Please upload onto Ocella the email trail below from **ADC Drainage Engineers** confirming the wording of the refusals for **Conditions 10 and 12 of LU/184/21/DOC** and **Condition 1 of LU/188/21/DOC**.

From: Roger Spencer <Roger.Spencer@arun.gov.uk>
Sent: 29 October 2021 08:49
To: Michael Eastham <Michael.Eastham@arun.gov.uk>
Cc: Paul Cann <Paul.Cann@arun.gov.uk>; Laura Gibbons <Laura.Gibbons@arun.gov.uk>
Subject: RE: Hampton Park

Further to your email below, could we refuse **Condition 10 of LU/184/21/DOC** on the following grounds?:

From: Roger Spencer <Roger.Spencer@arun.gov.uk>
Sent: 28 October 2021 18:26
To: Michael Eastham <Michael.Eastham@arun.gov.uk>
Cc: Paul Cann <Paul.Cann@arun.gov.uk>; Laura Gibbons <Laura.Gibbons@arun.gov.uk>
Subject: Hampton Park

PROPOSED PHASE 4 IN RELATION TO EXISTING PHASE 2

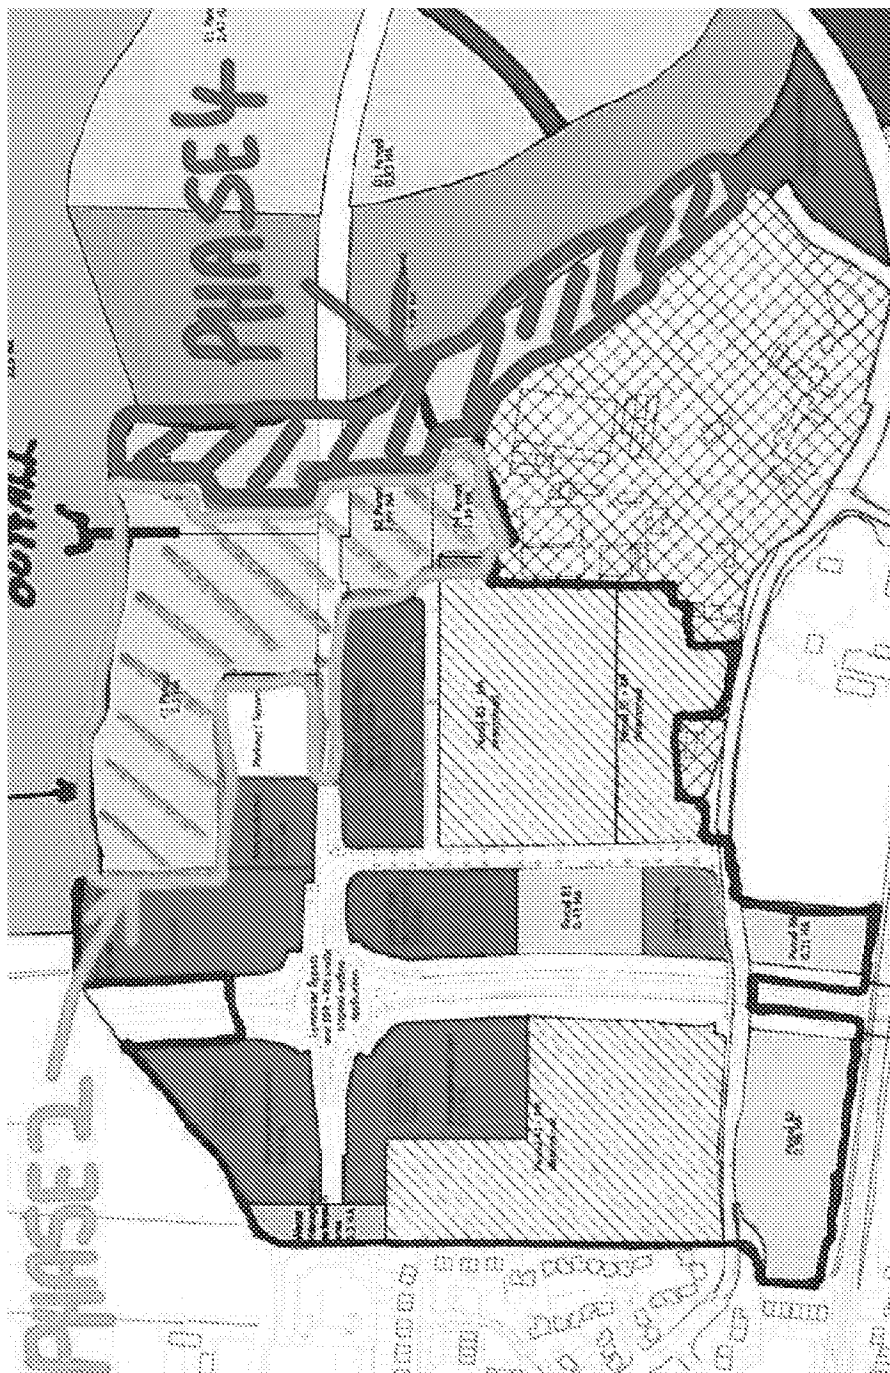
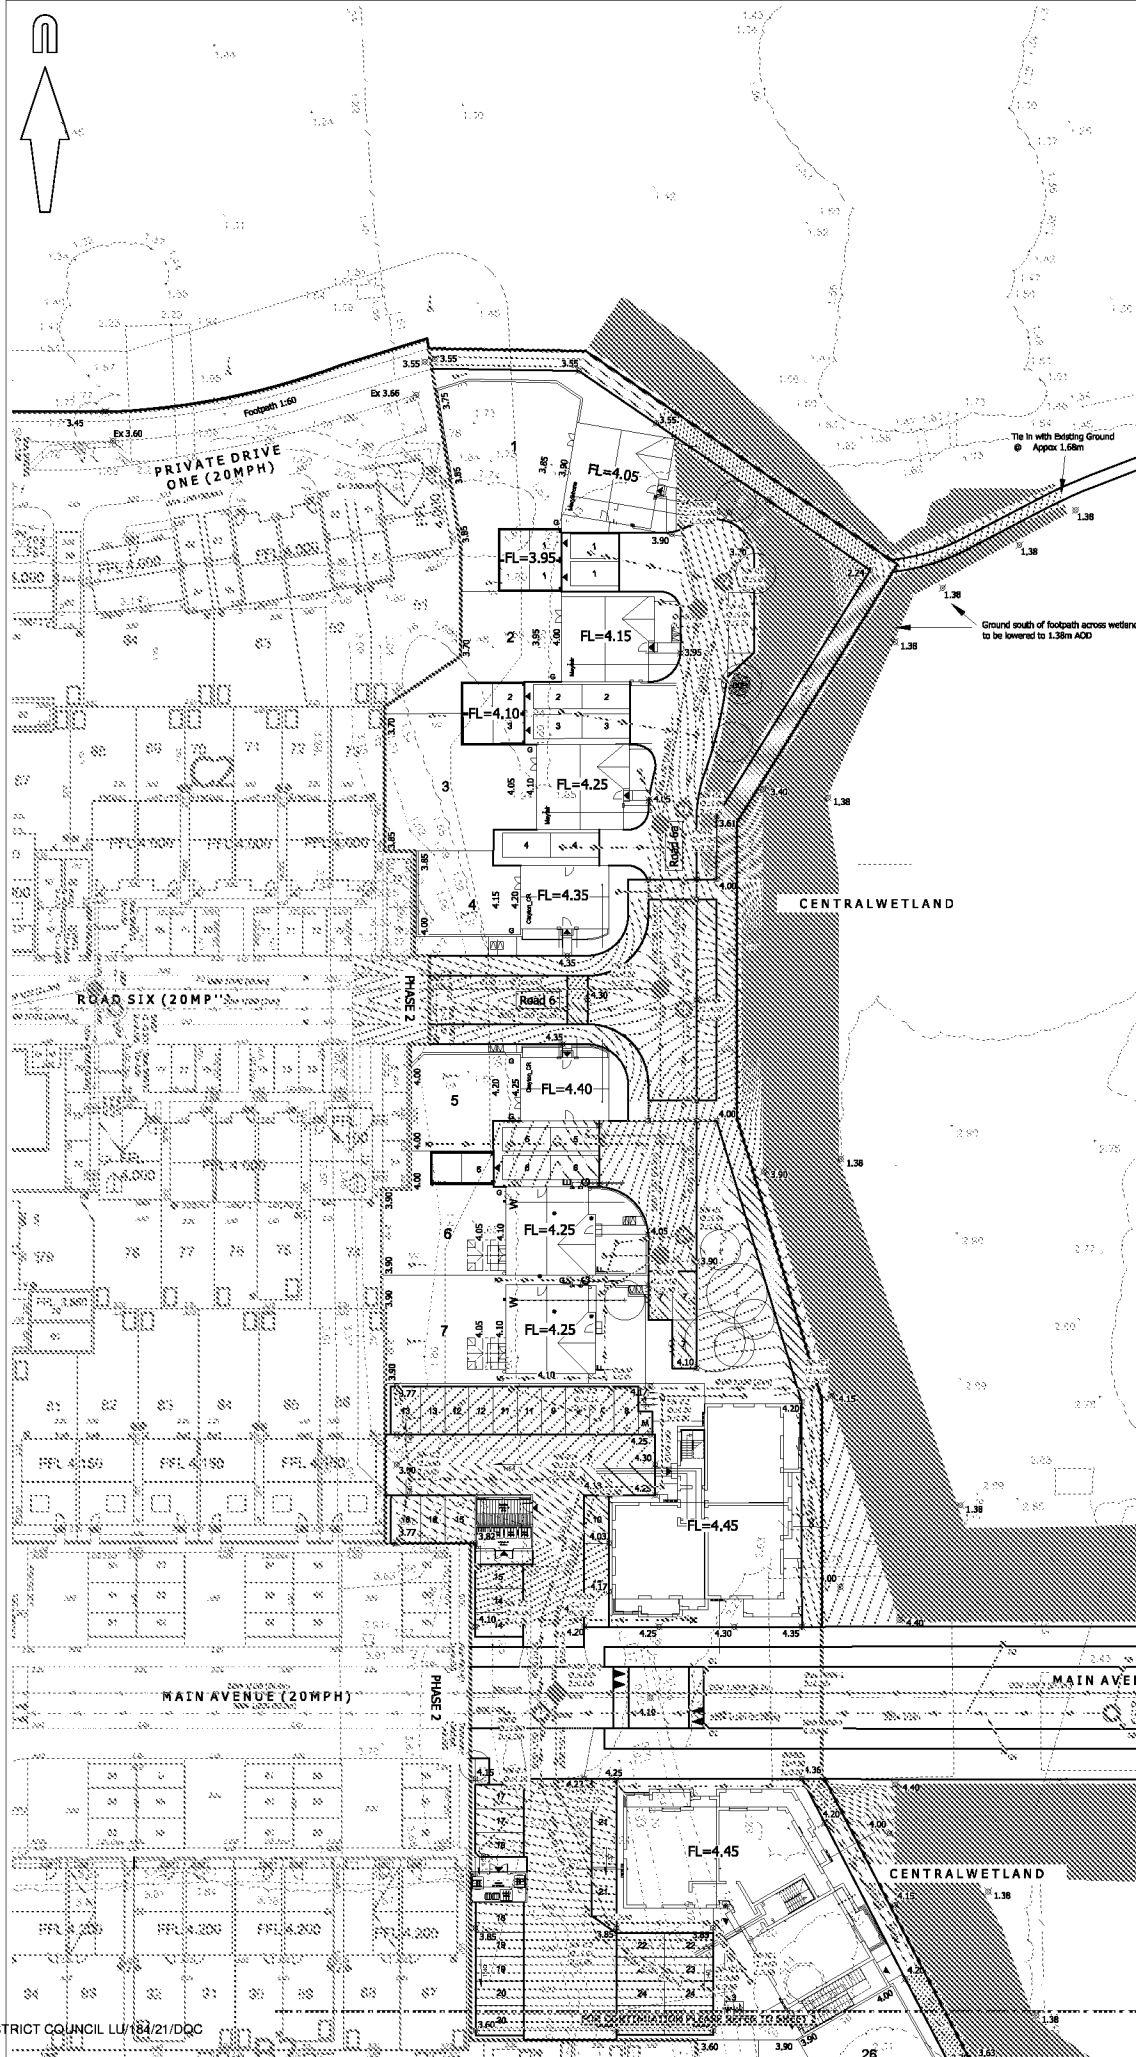
The outline does not mention using an engineered main swale – there is mention of providing swales that direct water to the wetlands. The Masterplan shows a main spine within the central wetlands but does not describe that this will be much more than a receiving mechanism for the other swales, to get water to the Black Ditch; it shows a rather meandering line, that would seem not to be needing much work on it. There is speak (at outline) of filling some ponds and ensuring other ponds that are used for attenuation, are outside of the flood zone, so as not to compromise flood storage. I accept that the ‘engineered’ main swale will help but the proposals are not well detailed; especially in terms of the relationship to Black Ditch. There is mention of Black Ditch water levels being at 1m AOD (ie the base/invert of the main engineered swale) but I cannot see mention of flood level likelihoods in Black Ditch or any sensitivity around this.

A plan in part 2 of the NTS has annotation to say that the swale is to tie in to the existing ditch– the existing ditch have no supporting data and there is no relationship on that plan shown to the Black Ditch (ie what accommodation works might be required off-site)

PHASE 4 CATCHMENT 01 & 02 WINDES PLAN (within overall west of wetlands model)

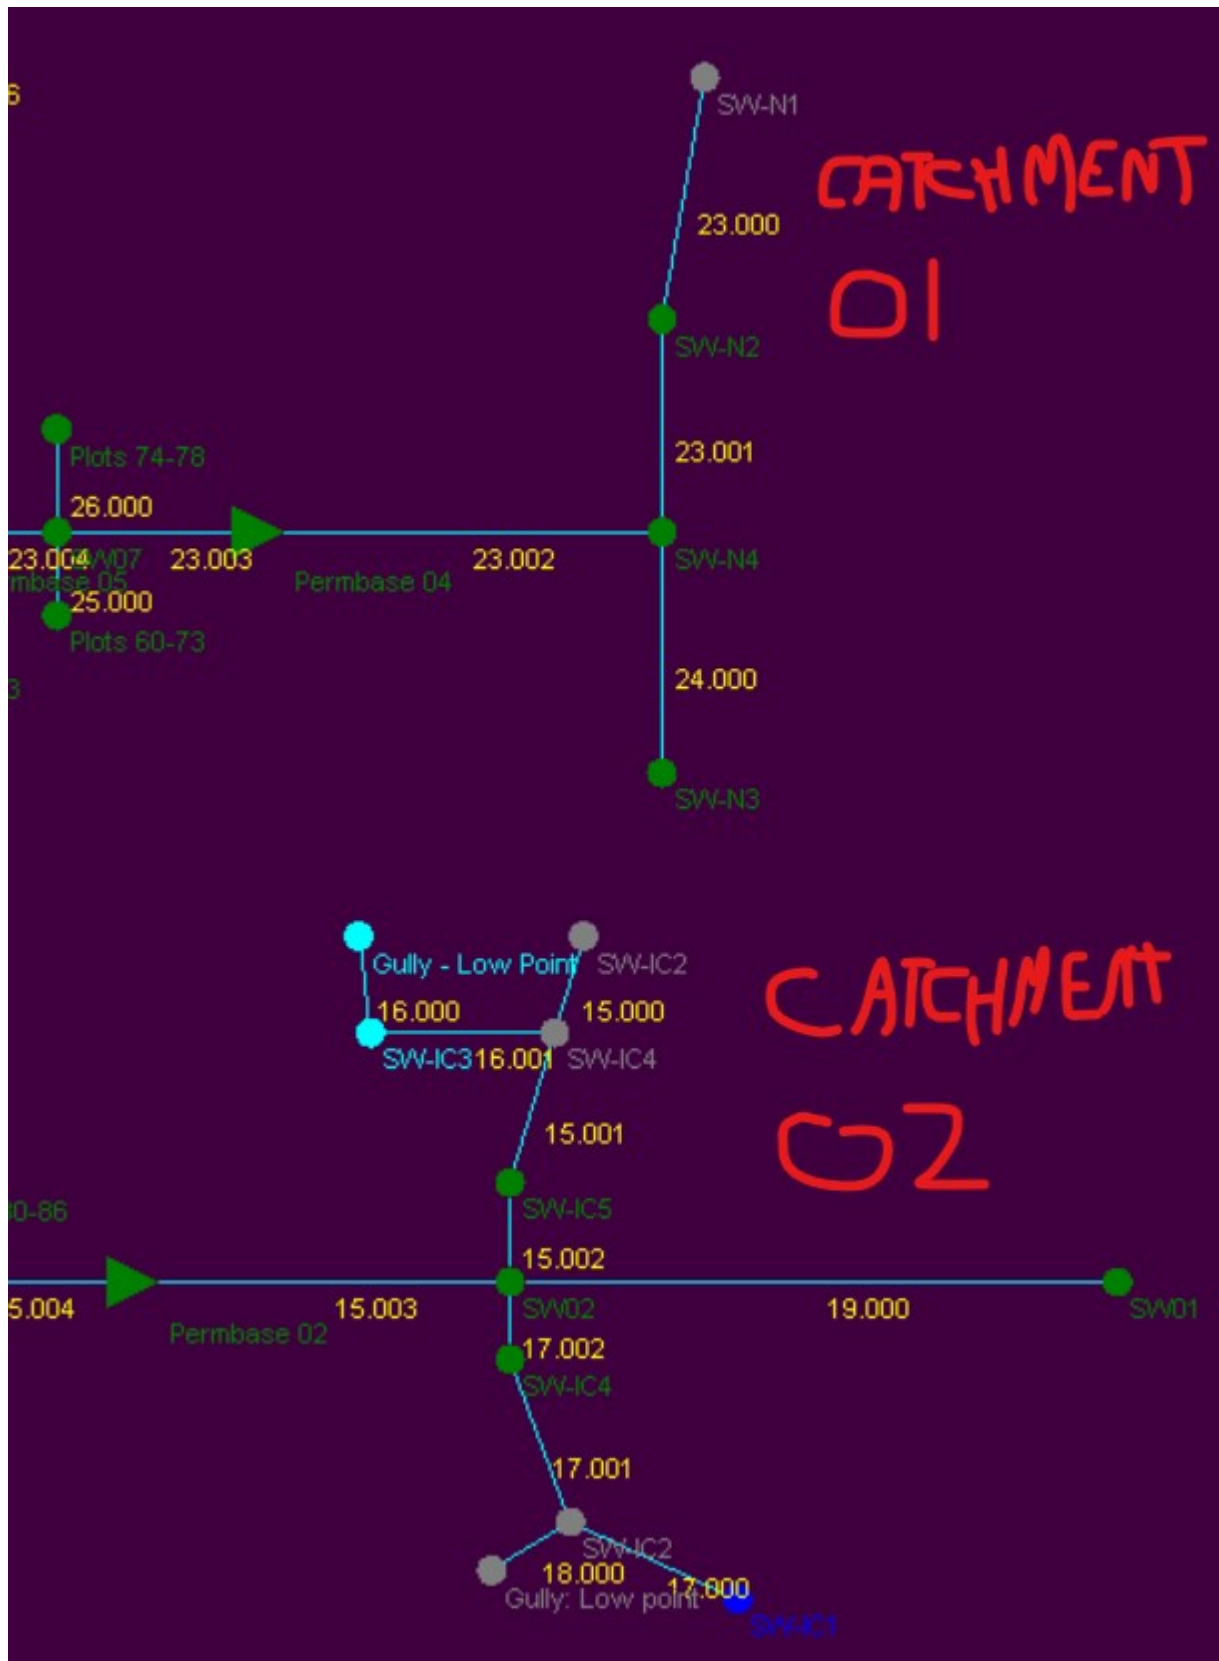
At outline, there is mention of 7 l/s/ha runoff rate (as well as seeking some betterment to this) whereas the NTS says 15.

We would nowadays look for 1:100 + 40% climate change. The Outline uses 20% but the NTS speaks of 30%

As an observation, the Outline mentions less attenuation for the parts of the system that are close to the wetlands , as they (the wetlands) are perceived as being able to accept greater flow rates but overall the attenuation would be to the agreed runoff rate. This will need careful consideration if this concept has been taken through to the DoCs.

I have not looked at the detail of the Central Wetlands proposals (in the NTS) but I know that colleague have concerns, not least about the lack of gradient to the main ‘engineered’ swale. Siltation could well be an issue – either from the development or carried onto the swale from the Black Ditch. There should also be an allowance for good practice in terms of ecological benefit.
